## POST EPC MEMORANDUM

RE: PR-2022-007851, SI-2022-02075-Buddhist Temple, Site Plan – EPC Major Amendment

**Project # PR-2022-007851**

SI-2022-02075 - Site Plan- Major Amendment

EPC A.1

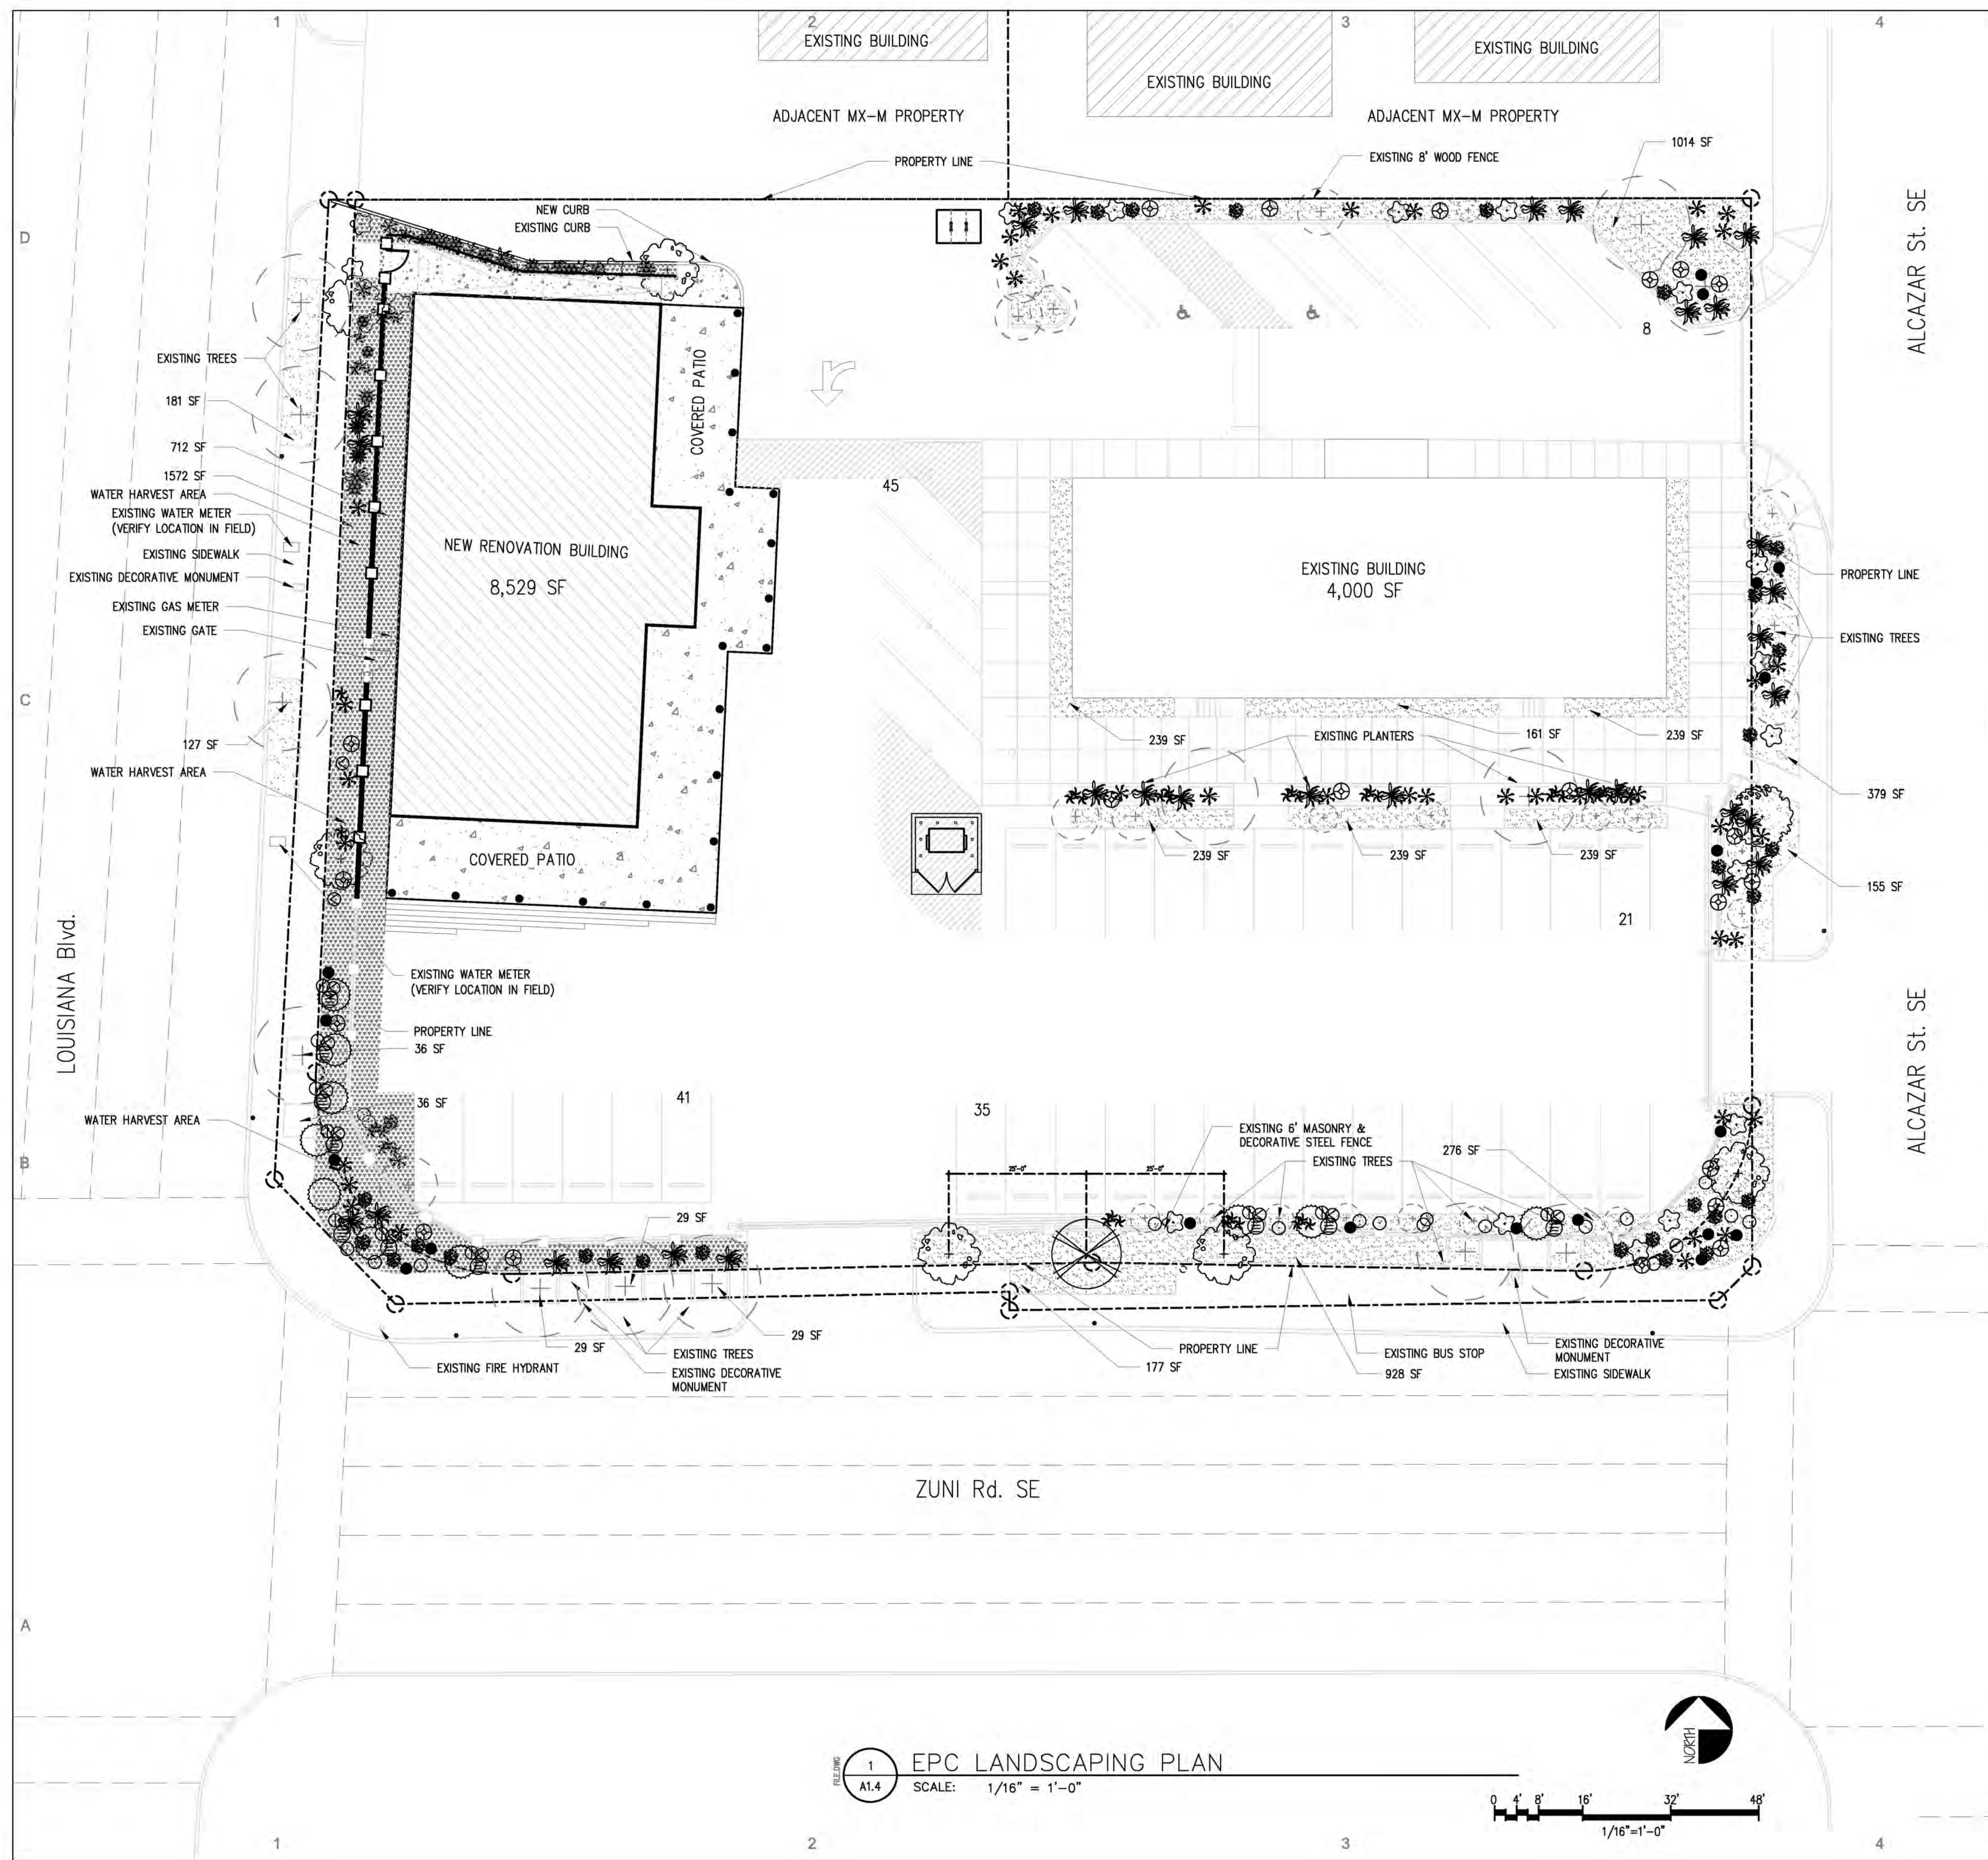
3. Condition has been met.
4. Condition has been met.
5. A variance for the 8-foot wall must be obtained pursuant to IDO 6-6(O) VARIANCE – ZHE. The existing wall along Zuni Rd. in the controlling Site Development Plan was constructed prior to the IDO effective date in 2018. At that time, 8-foot walls were allowed and there were no height limitations for walls in non-residential zones (see Zoning Ordinance in effect prior to 2018). If the applicant wishes to develop an 8-foot wall that matches the existing wall, a variance must be obtained to meet maximum wall height standards in IDO 5-7 before construction.

DWL Architects, Agent for Wat Prathat Doi Suthep Buddhist Temple of New Mexico, has satisfied Conditions for NOD dated December 15, 2022 (PR-2022-007851, SI-2022-02075) Site Plan EPC, Major Amendment. A variance for the proposed wall along Louisiana Blvd. must be obtained before construction.

4. **Site Plan:** Site Plan must show all required dimensions including dimensions between light fixtures. The site plan reflects the required dimensions and annotates the site lighting at each CMU pilaster, both existing and new, are on a 12'-0" on center spacing along Zuni Road and Louisiana Boulevard SE. The covered patio of the residence is illuminated from fixtures on its exterior soffit. Existing solar landscape ground lighting remains in-place and will be augmented with new fixtures once the project is completed within the new landscaped areas.

PROJECT NUMBER: 20_1611.03
 CAD DWG FILE: DWL-NM_APS_OSUNA
 DRAWN BY: S.S.
 CHECKED BY: W. EASTMAN
 SHEET TITLE: EPC LANDSCAPING PLAN
EPC A.2
 XX OF XX SHEET

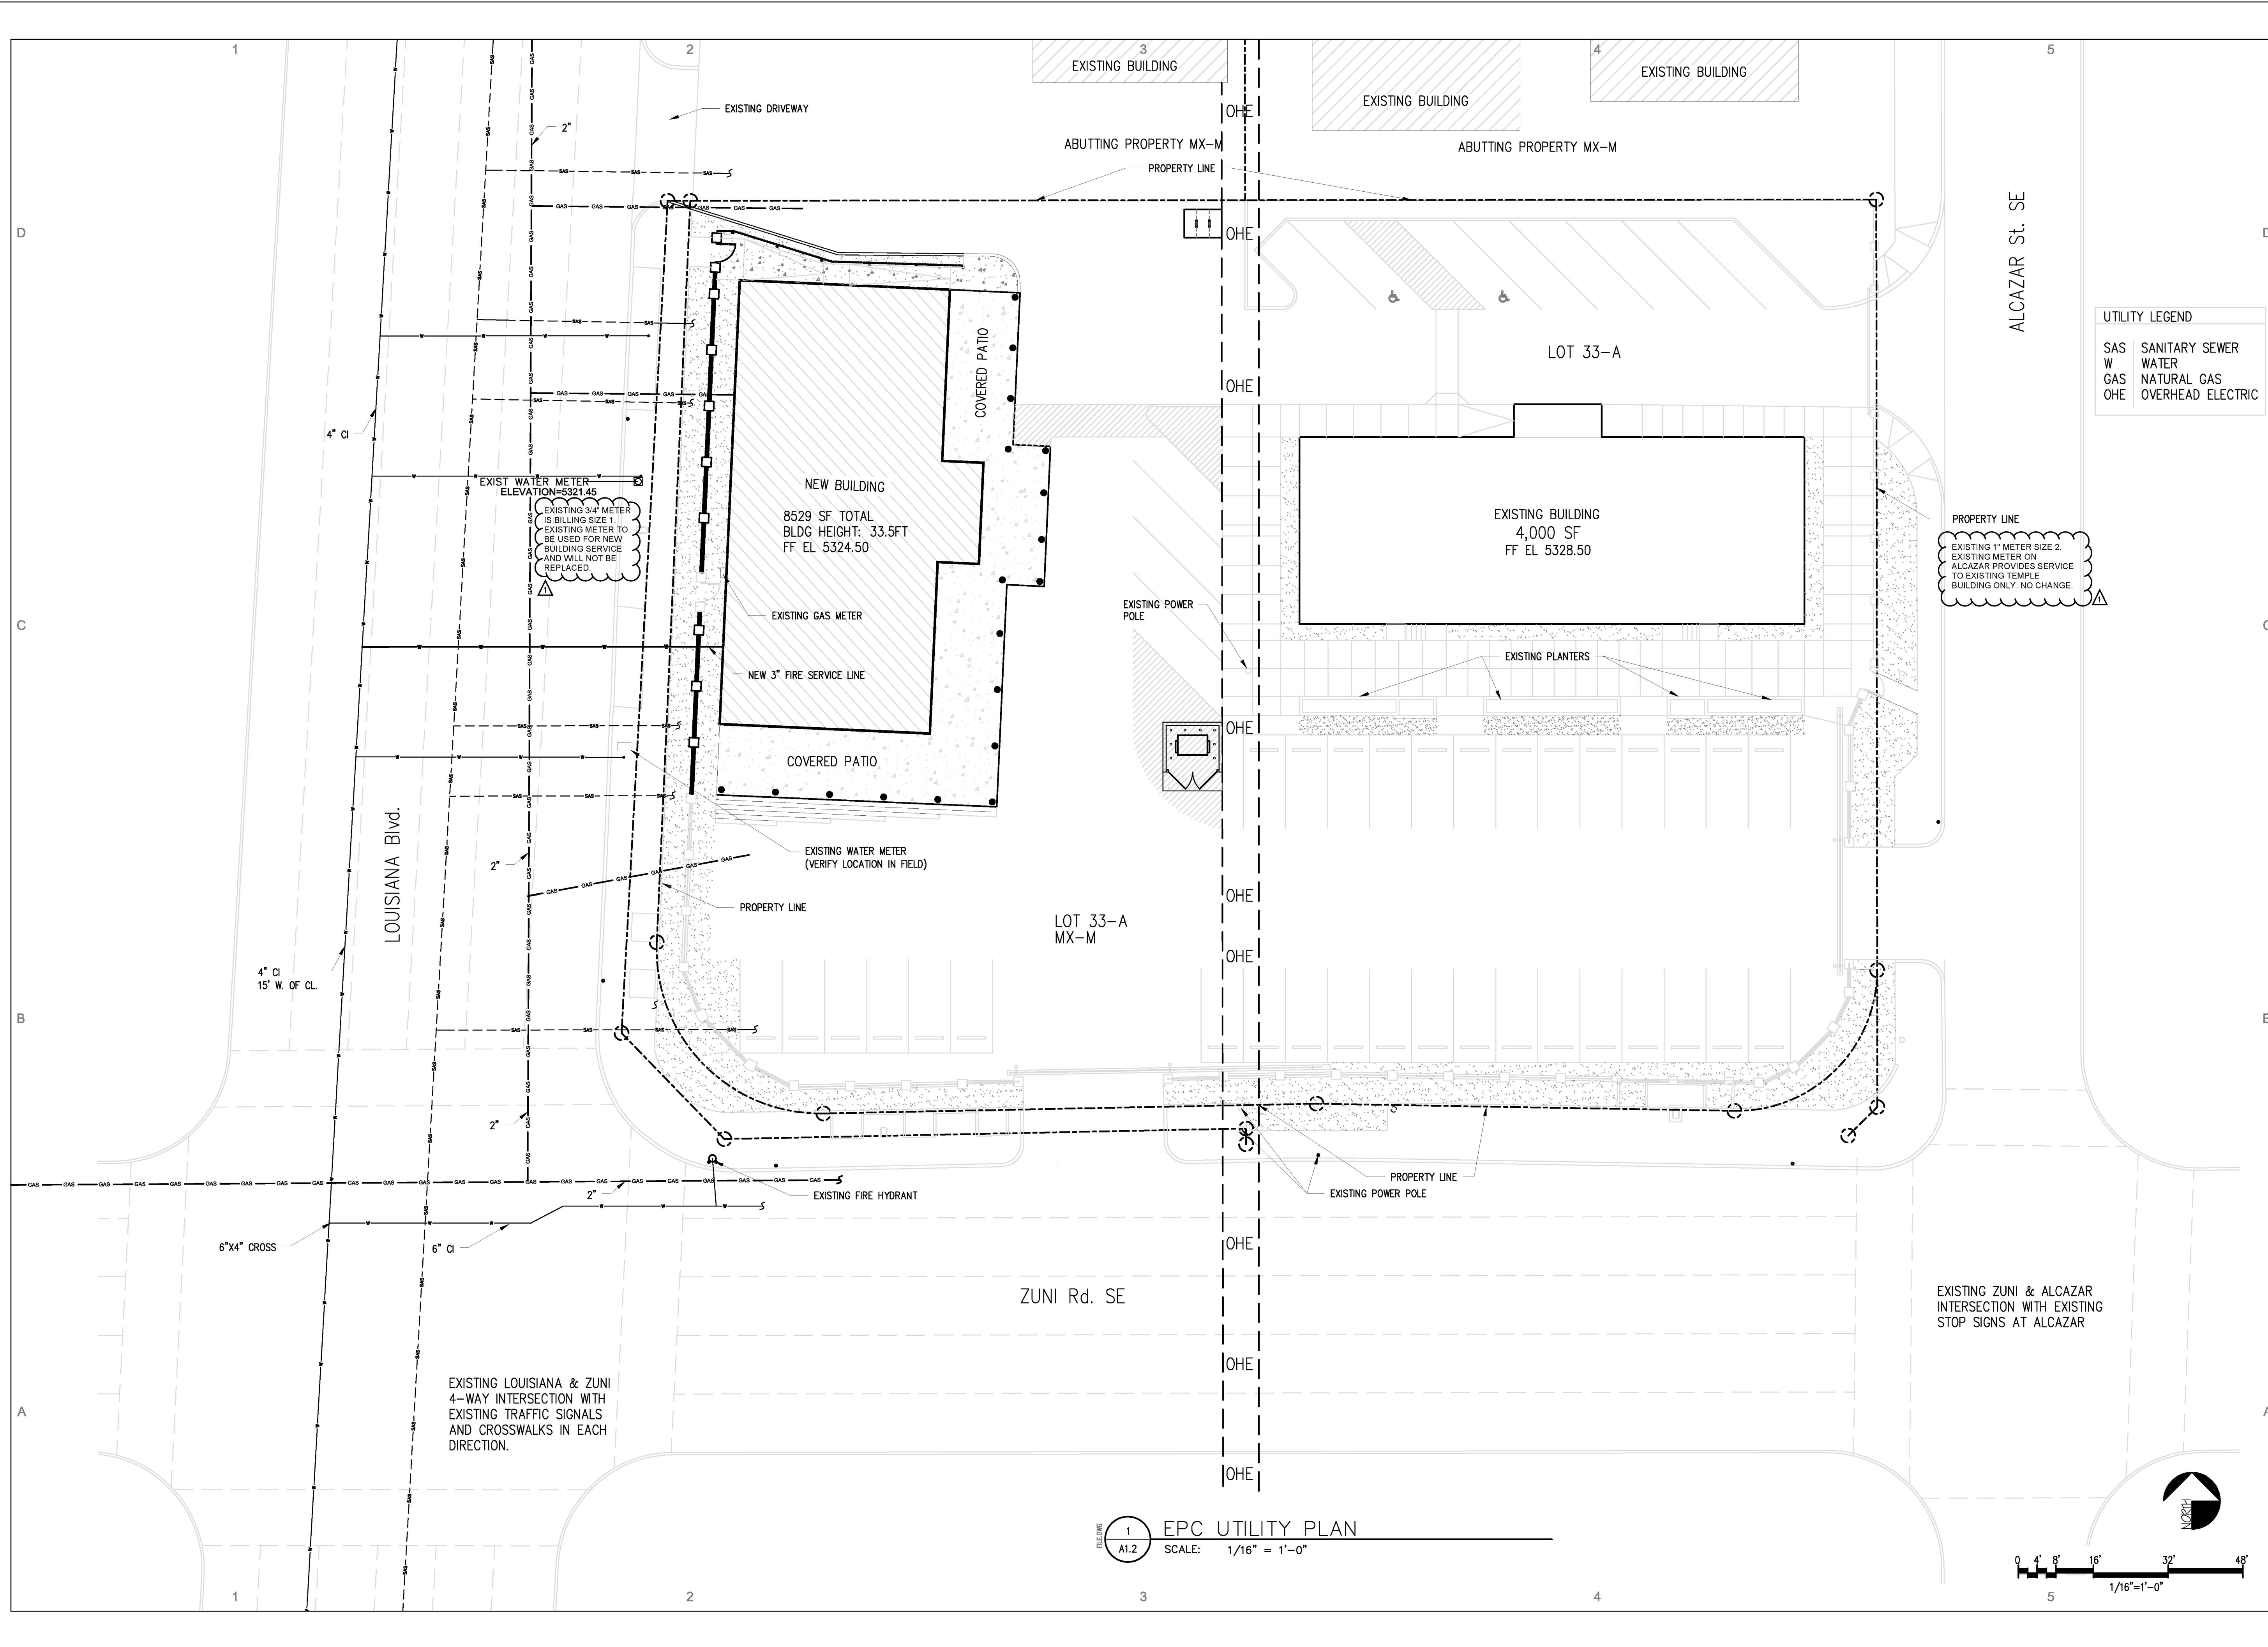
3. Landscaping: The applicant must show that the required 75% of ground cover is being provided.  
*The Site Landscaping Plan A-1.4 reflects that the required 15% landscaped area has plantings with trees and/or groundcovers over 75% of the landscaped areas. Site Area 49,658 SF (1.14 acres) less*

existing building 4,000 SF plus new building 8,529 SF equals 37,129 SF. Required landscape area 15% = 5,569 SF, provided landscape area 7,047 SF (18%).
